Construction of 8 Cottage Developments consisting of 90 single family units and associated infrastructure on proposed 8 lot project site.

RE: DRB Project Number: 2021-006261

I am in receipt of comments provided on 12/06/2022 and have provided the following revisions, responses to those comments:

AS110

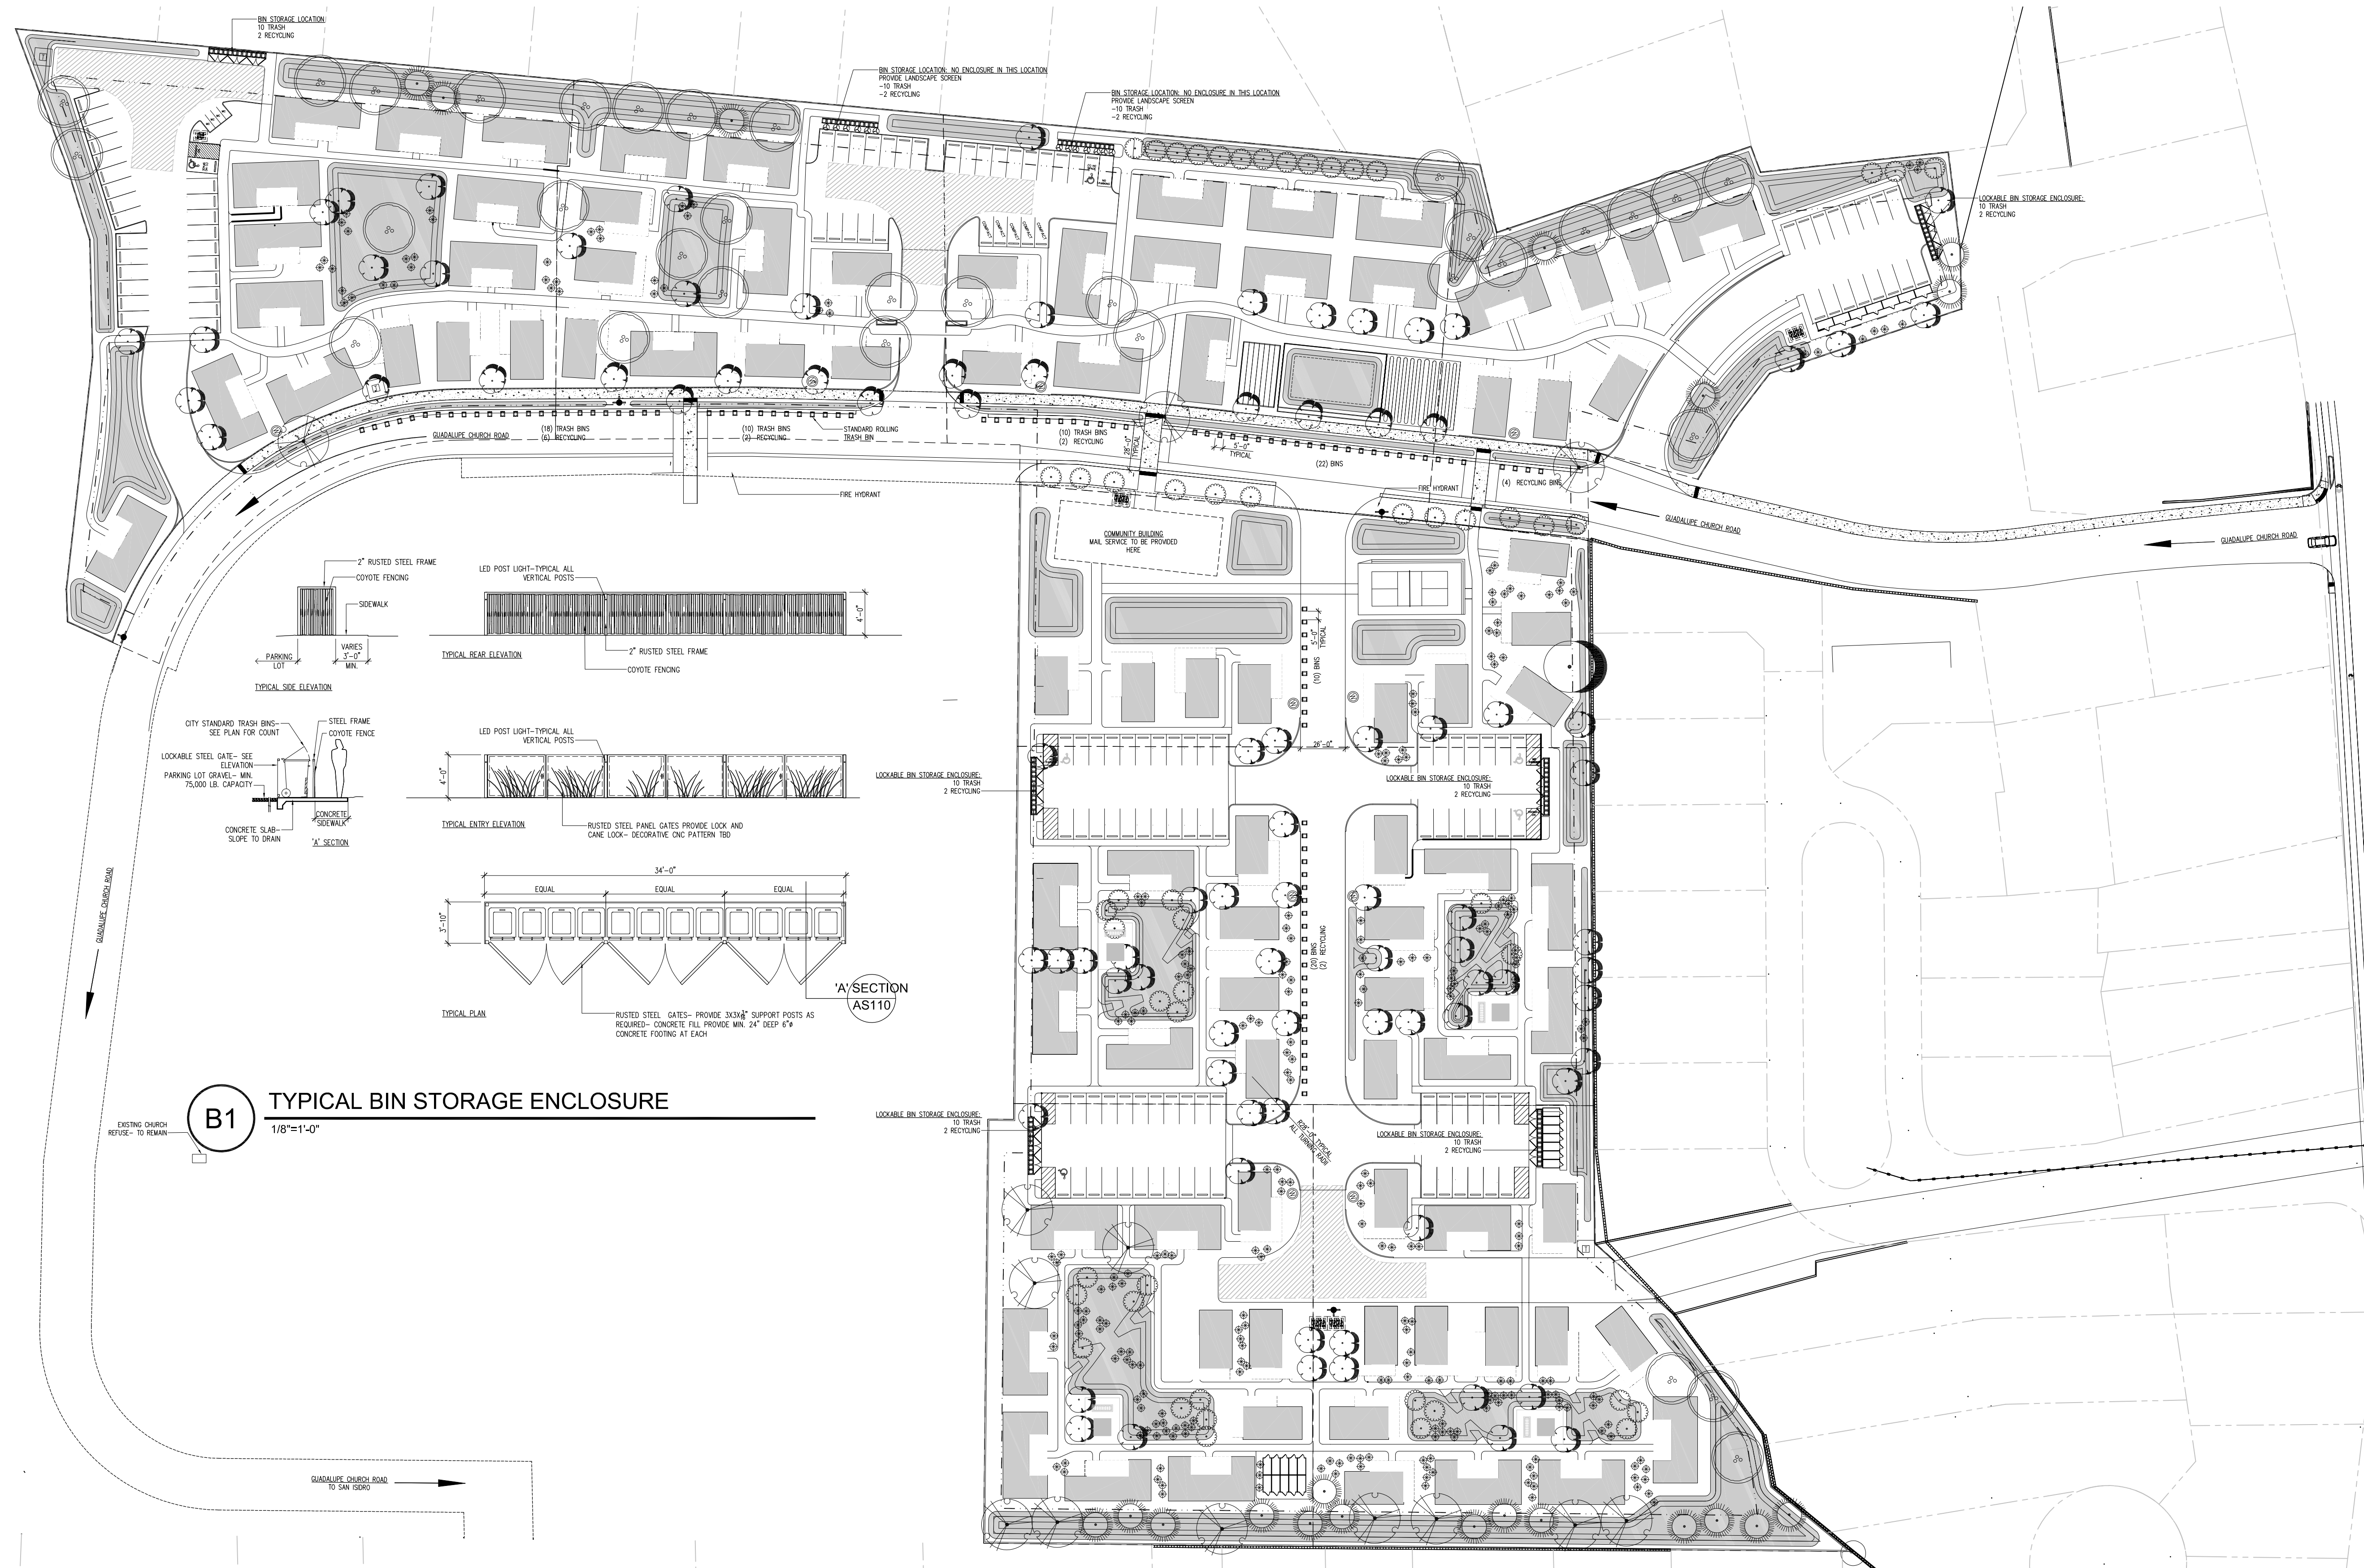
3. Did you obtain Fire Marshal approval and Solid Waste Approval for the plans.
Response: Both an approved Fire one, and Solid waste sheets, F1 and AS110 respectively, have been included in the application packet for your review. See pages 83 and 84 of 159.

Sheet Number:
TCL1

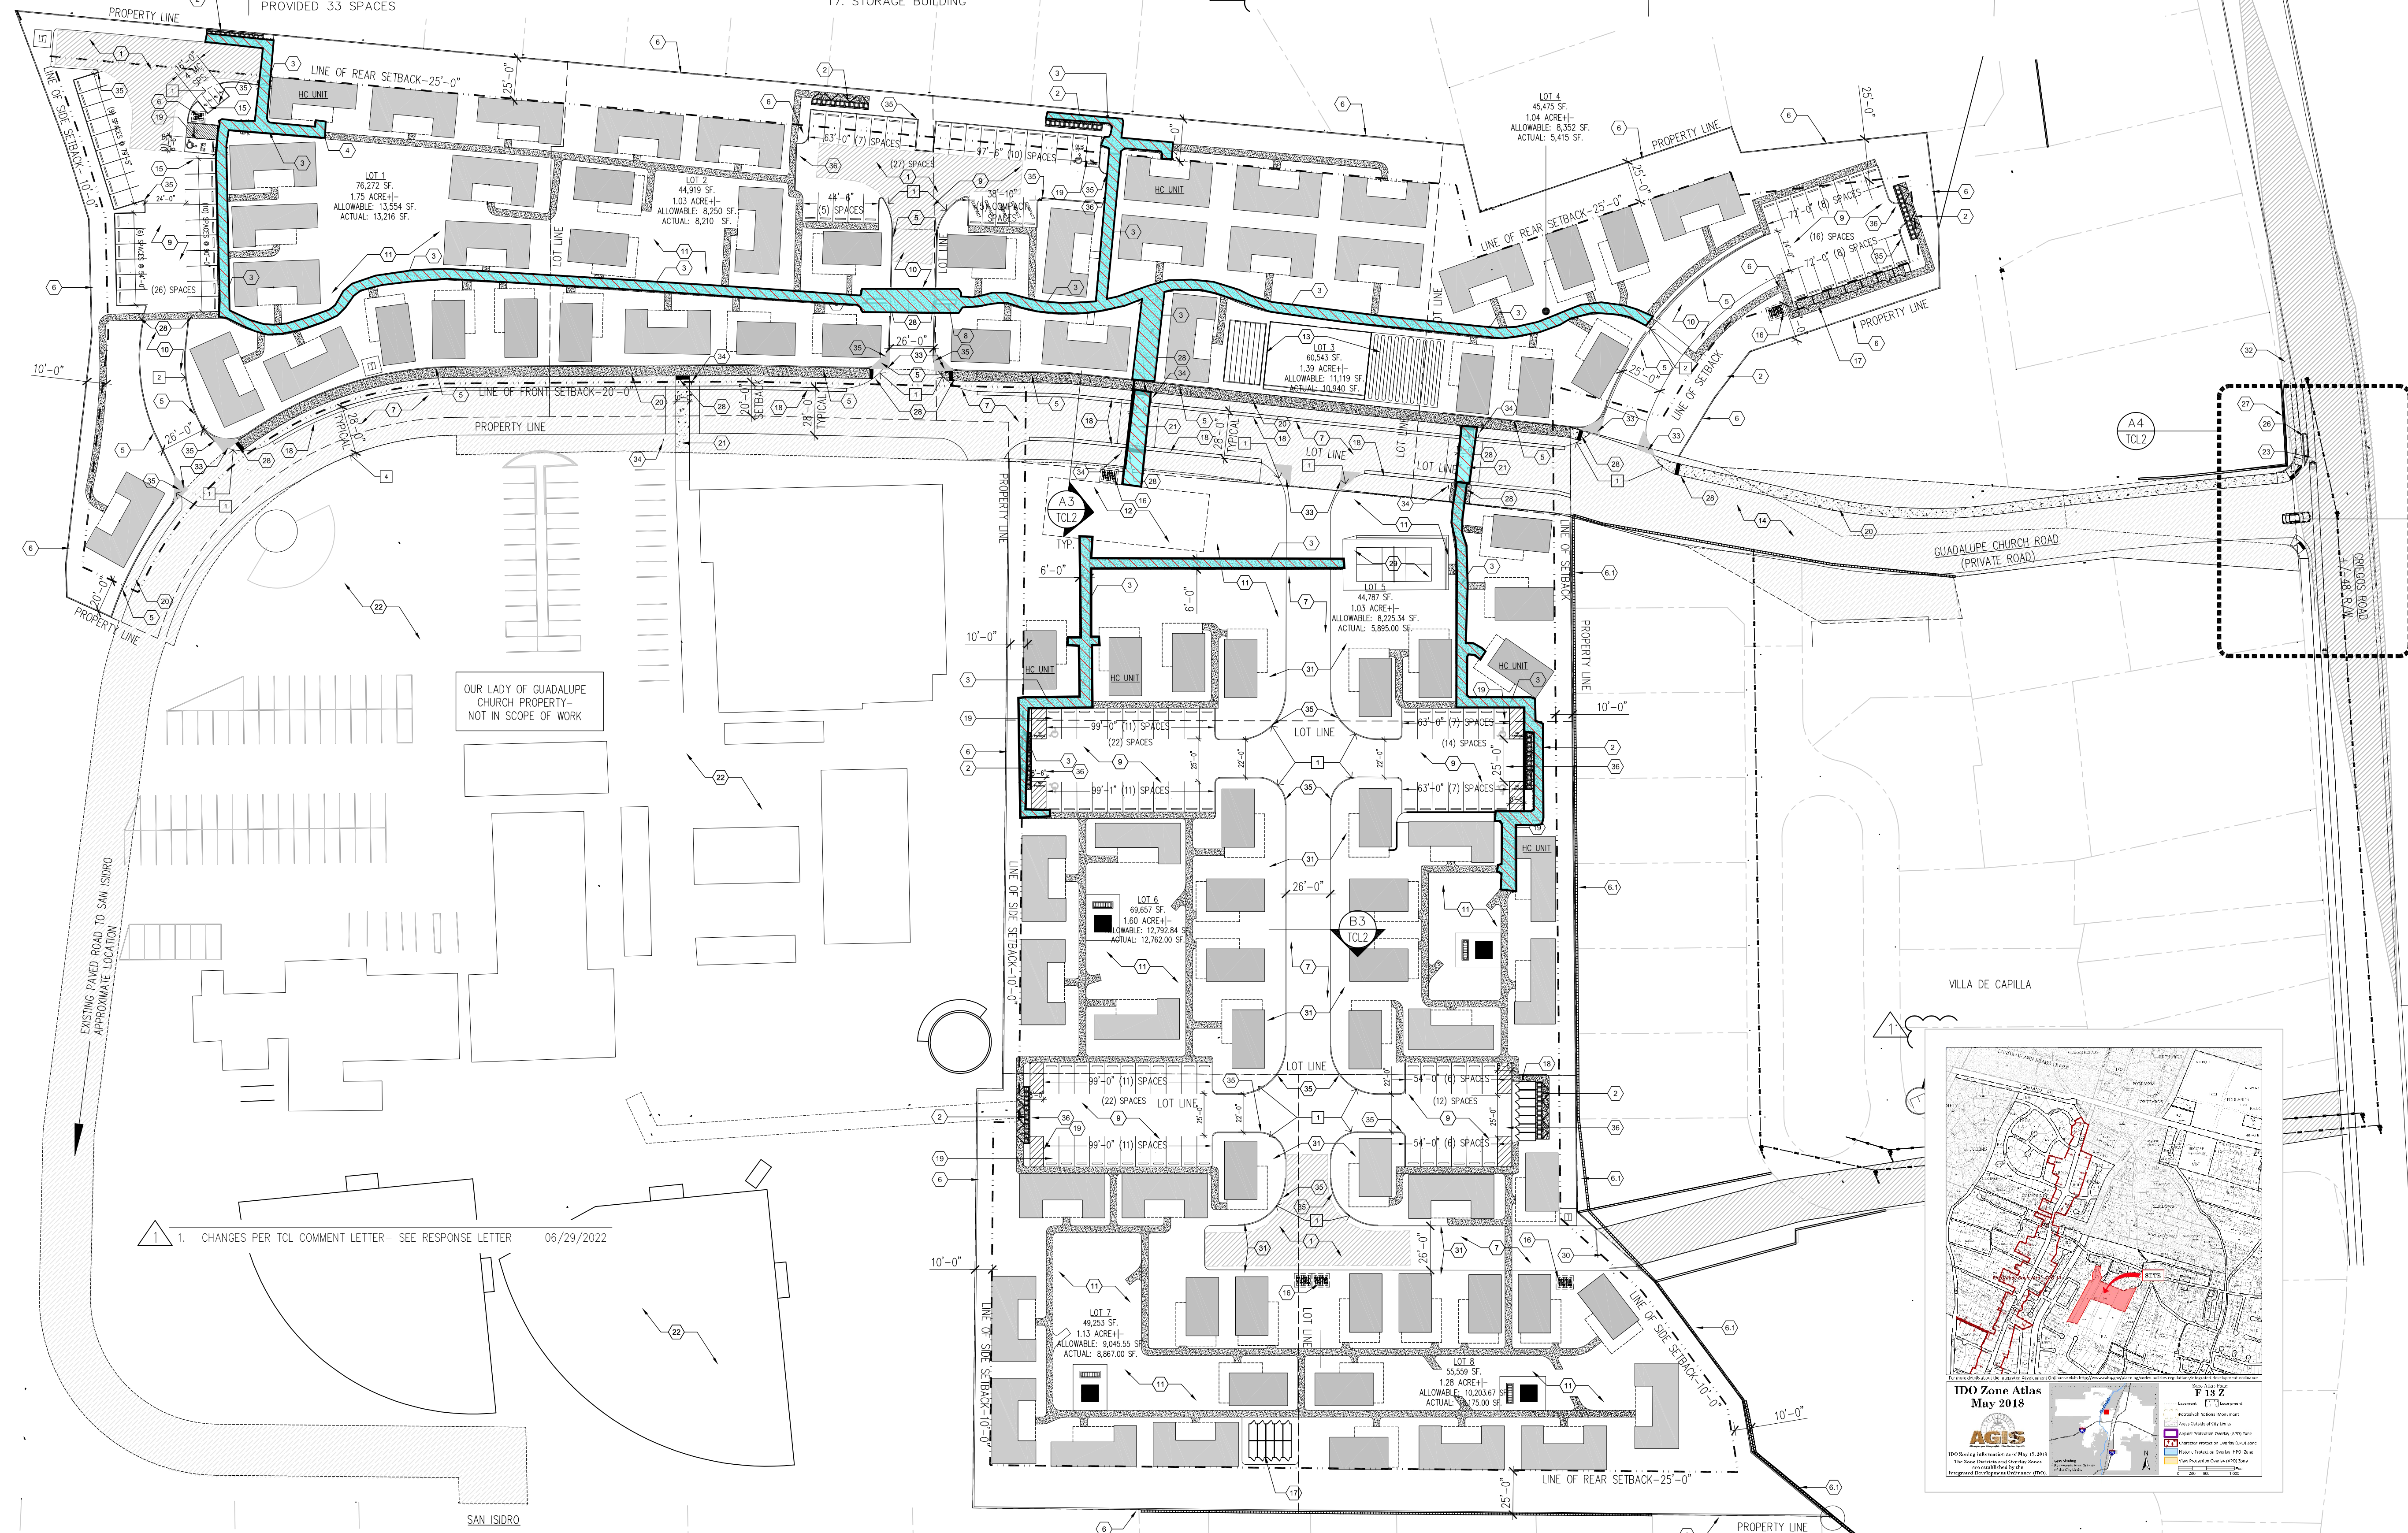
2. Please Show intersection clear site triangles at the intersection Guadalupe Church Road and Griegos Detailed in Figure 7.4.93 of the DPM.
Response: Sheet TCL01 of the approved TCL includes a reference to Table 7.4.65.2 which sets the parameters for figure 7.4.93 of the DPM. The site triangle in question has been indicated and dimensioned on the same sheet but does not directly reference figure 7.4.93.
